OUT16/25429

Lucas Heights Resource Recovery Park (SSD 6835) Comment on the Response to Submissions Report

The Department has reviewed the Response to Submissions and provides the following comments.

Figure 1.2

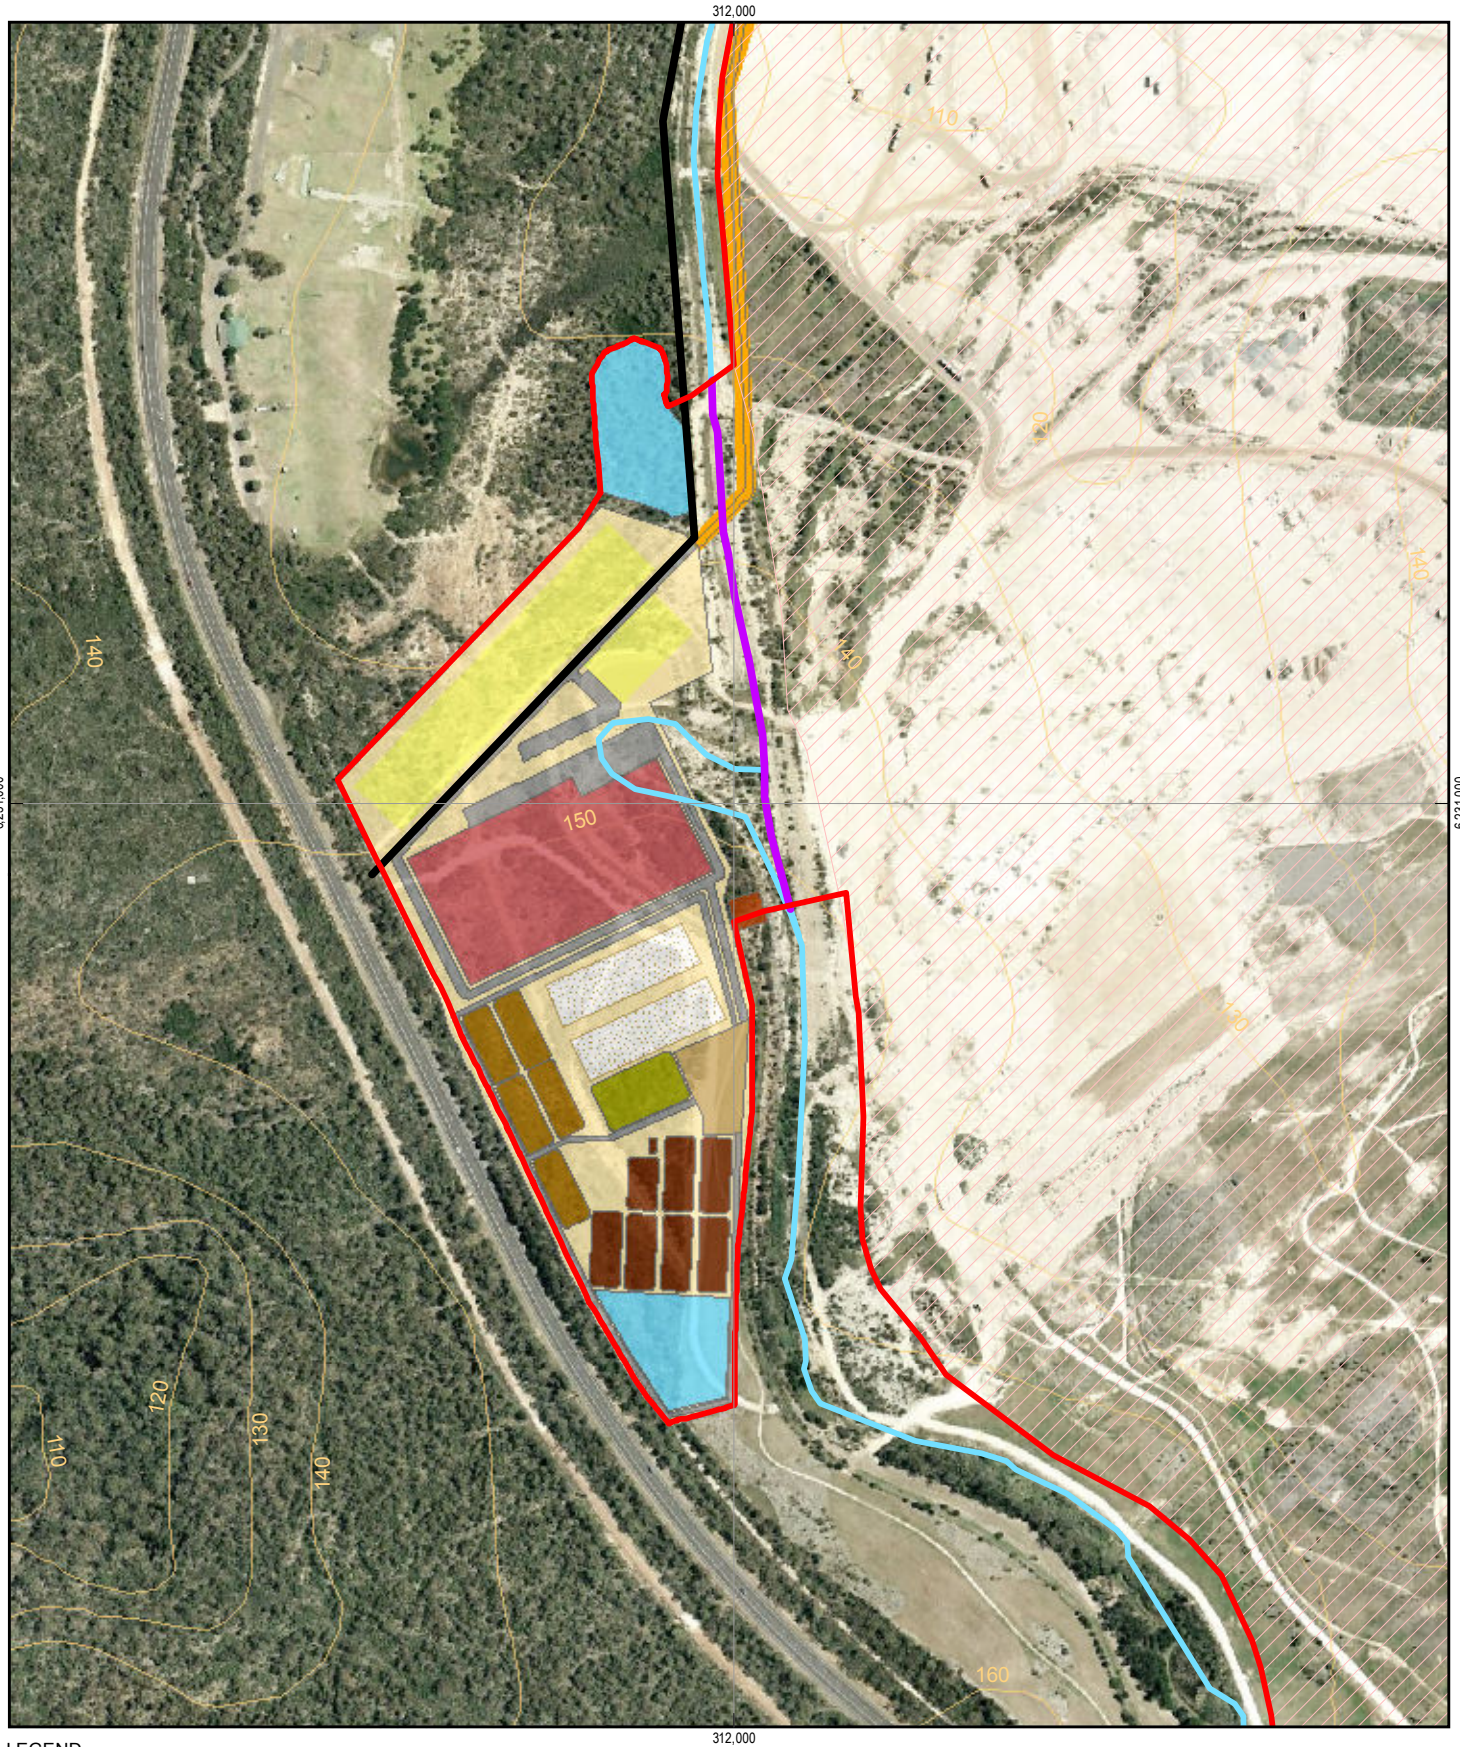
- The proponent has indicated at 9.1.1 that a vegetated riparian zone of 10m either side of Mill Creek is proposed, but also at 9.1.2 that the previous plan approved in 2006, which required a 20m corridor either side of the creek, will be used as a basis for the works. The proponent should provide clarification, with consideration of the *Guidelines for Controlled Activities on Waterfront Land* (DPI 2012).
